Addendum No. 1

Contract ID: C202310 WBS# 45060.3.ST1

Buncombe County (I-5122)

Milling, Resurfacing, Concrete Pavement Slab Repair, Concrete Deck Repair, and Shoulder Reconstruction

**CONSTRUCTION SEQUENCE  
(TYPICAL SECTION NO. 1)**

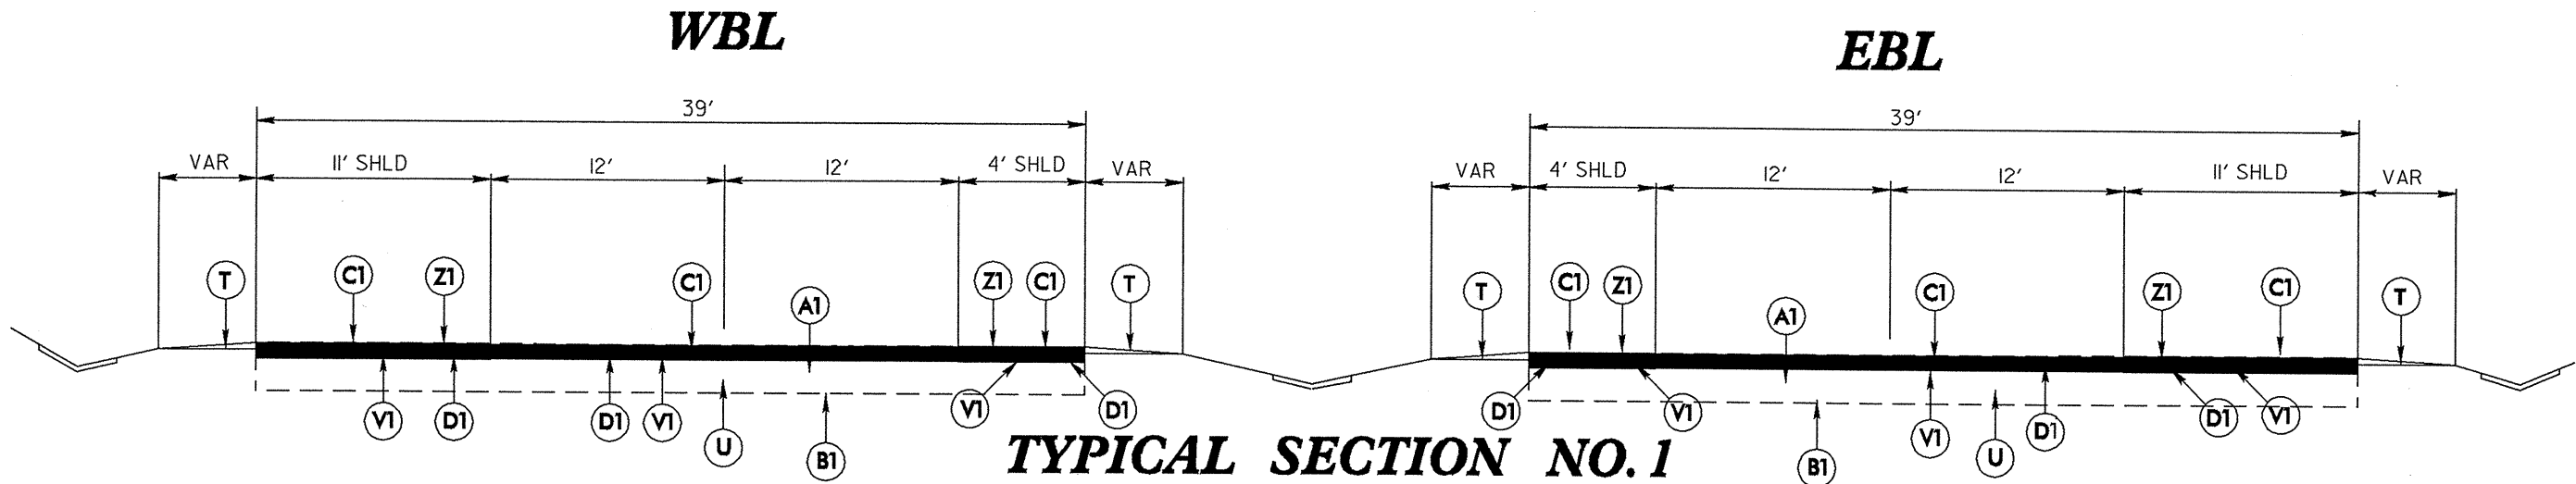
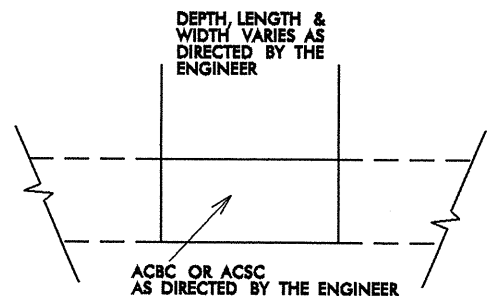
Sketch Map Sheet No.2 has been revised to include a "Construction Sequence". Please void Sheet No.2 in your Sketch Maps and staple the revised Sheet No.2 thereto.
